Re: Objection to MP08_0244 MOD 1 Modification Request for Mixed Used Development at 23-37 Lindfield Avenue and 11 Havilah Lane, Lindfield

As a resident of Lindfield, I/we wish to lodge an objection against the proposed Modification of the subject development based on the following grounds:

1 SHADOW DIAGRAM - 21stDEC_9AM
5003 SCALE1 : 650

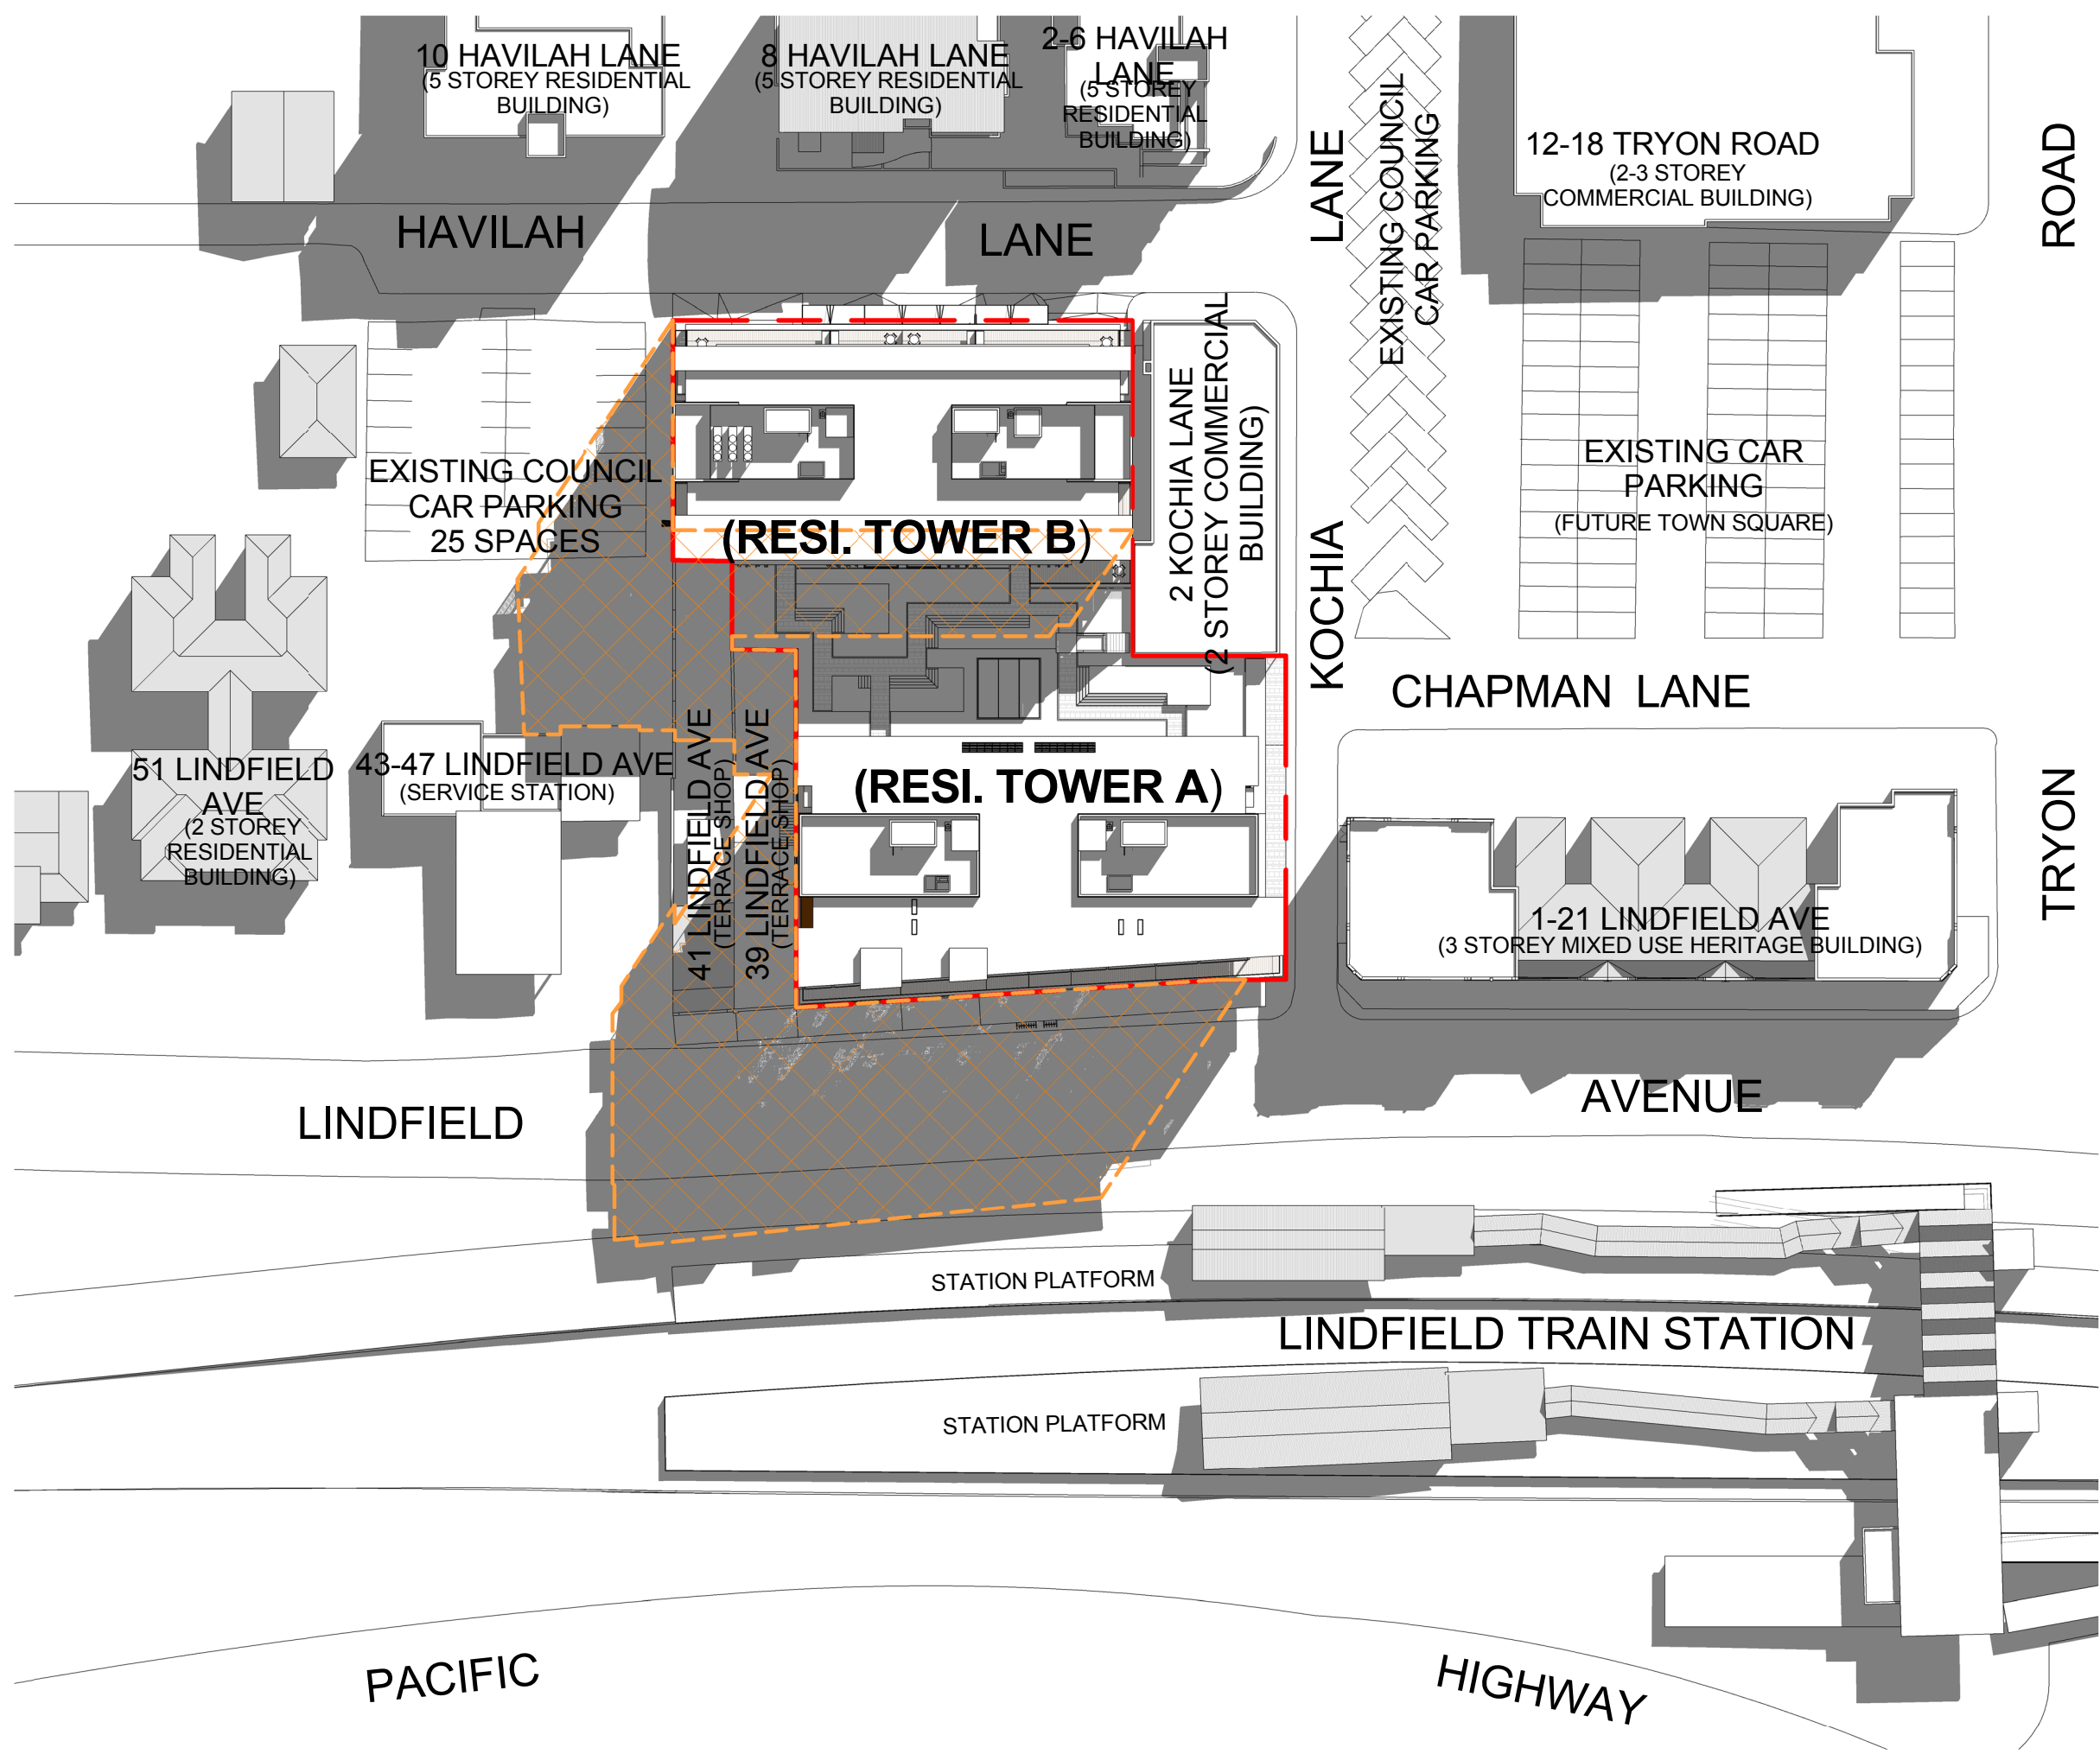
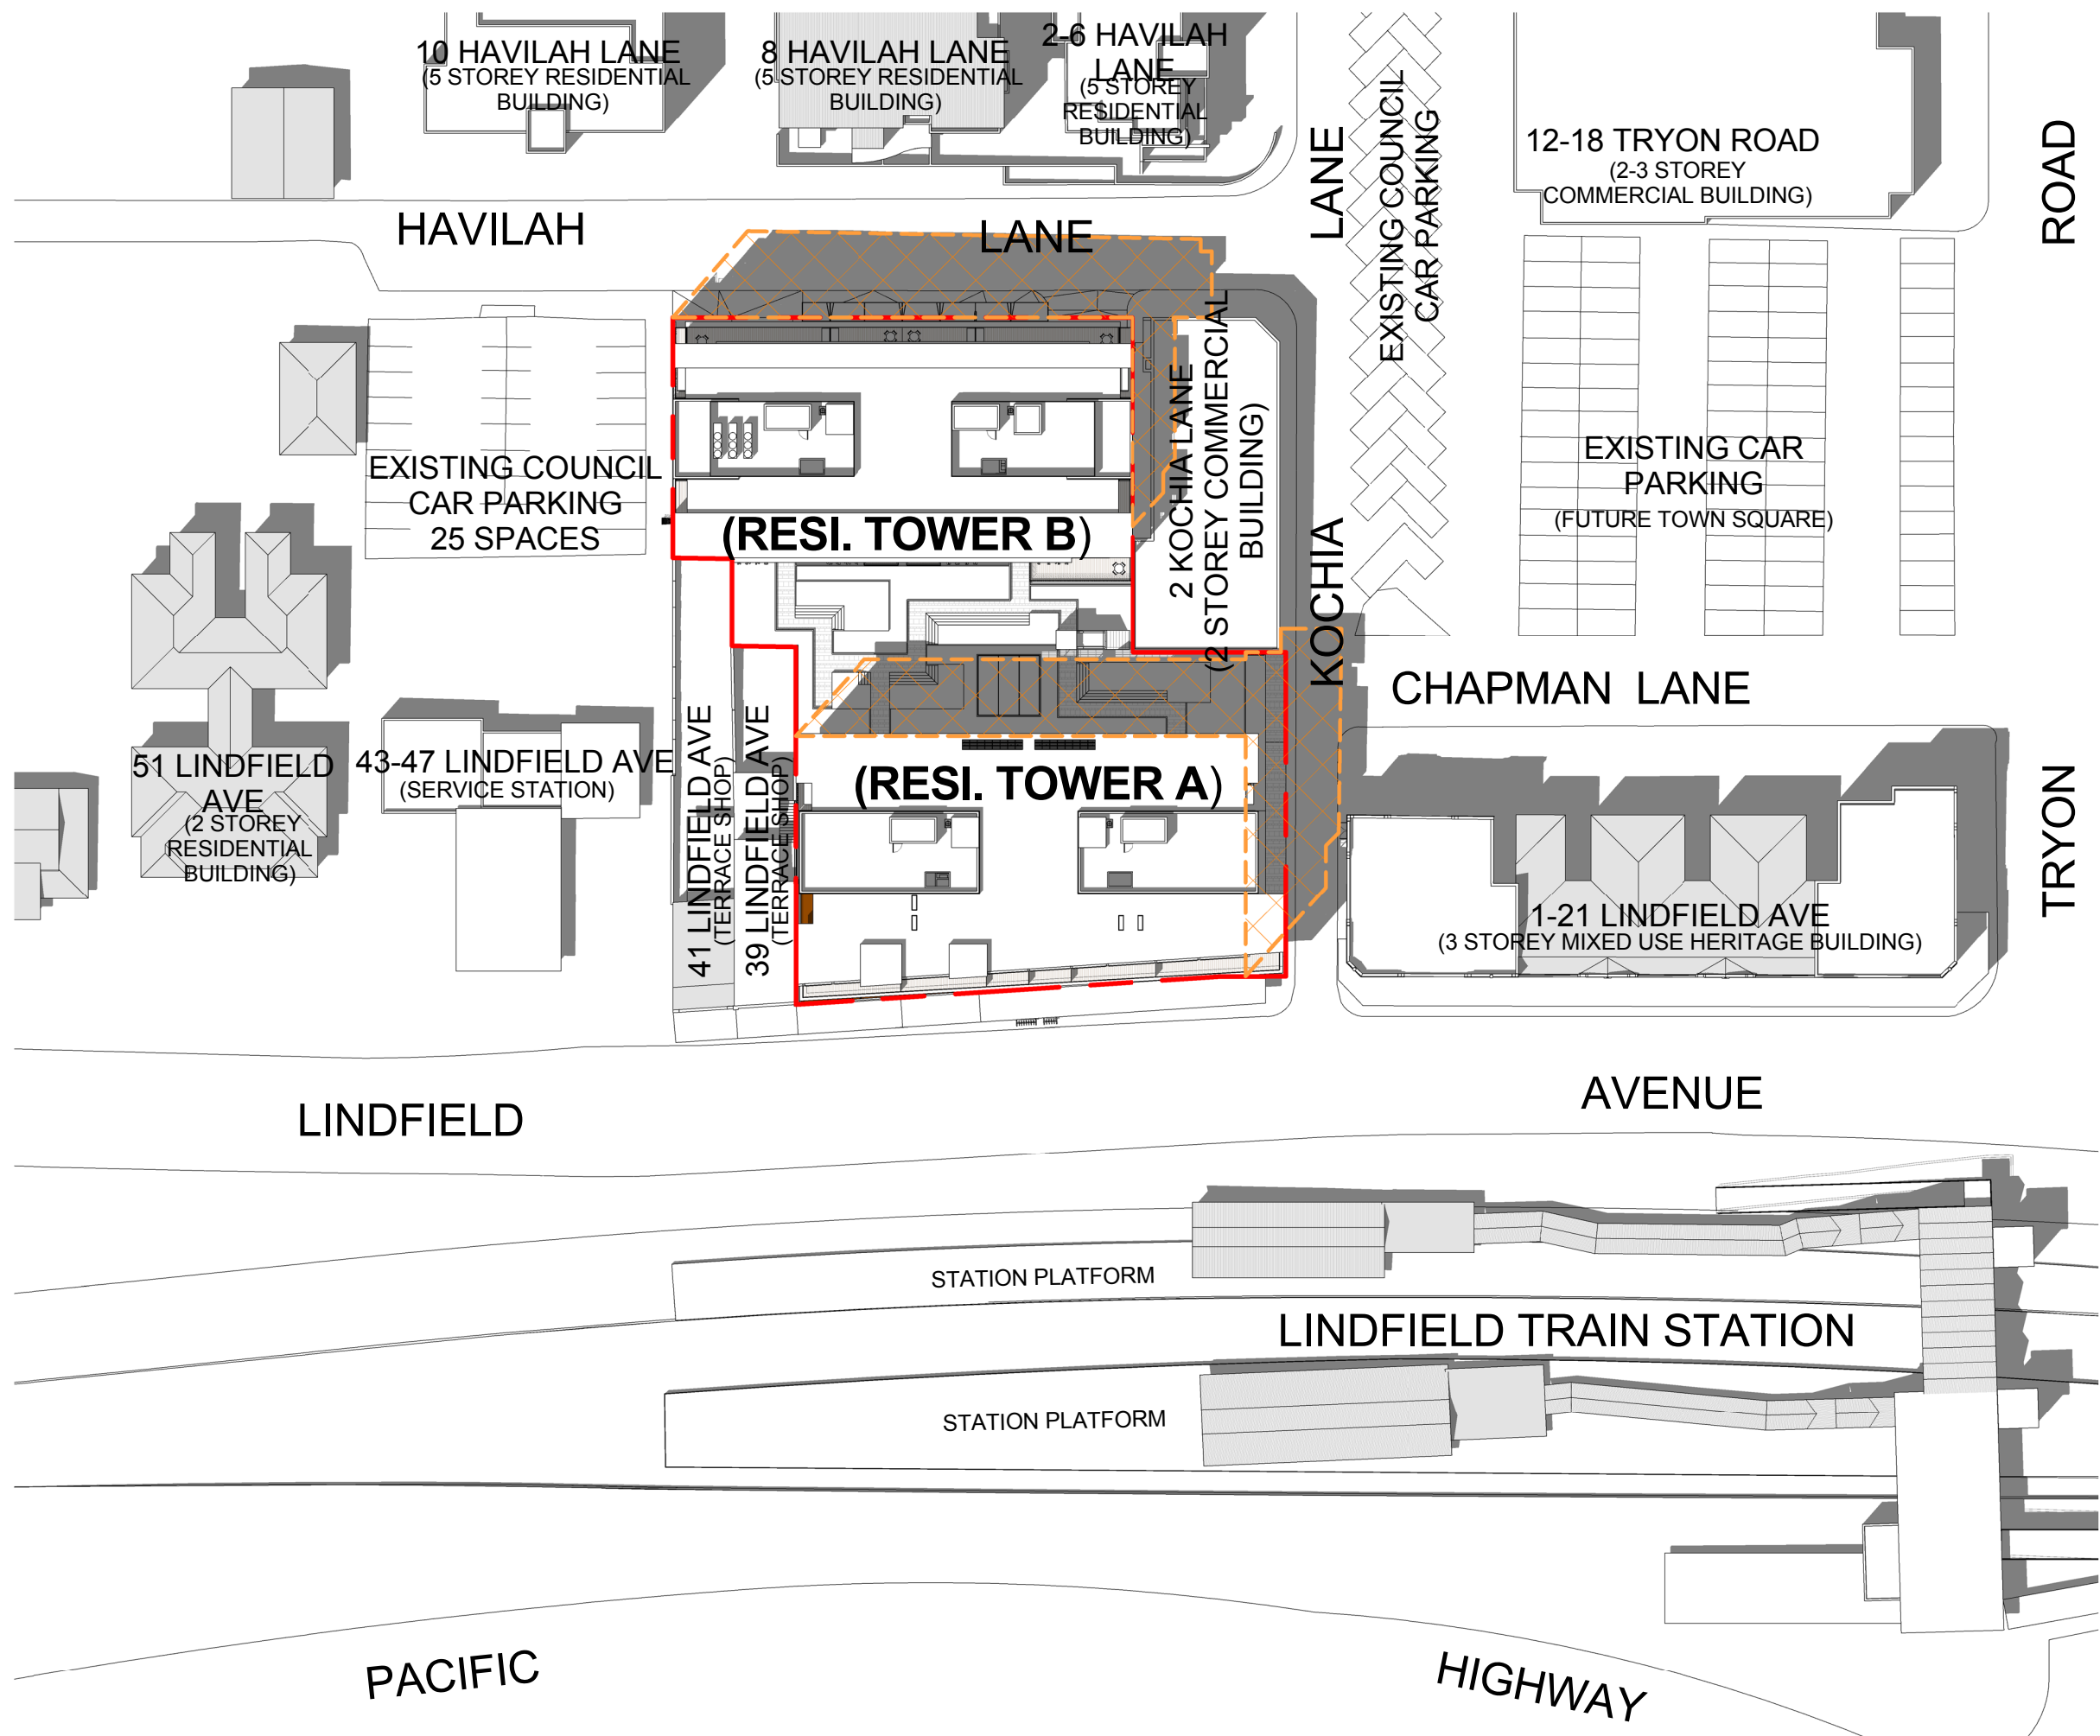
- The additional storeys create new adverse shadowing: a) for residents in the Havilah Lane apartments, particularly after 3pm b) for the popular outdoor café and central Lindfield hub area at 12 Tryon Road in afternoons, particularly in winter and c) for all commuters on the city bound Lindfield rail platform, instead of 50% of the year as approved, it will now be in shadow in the mornings 75% of the year
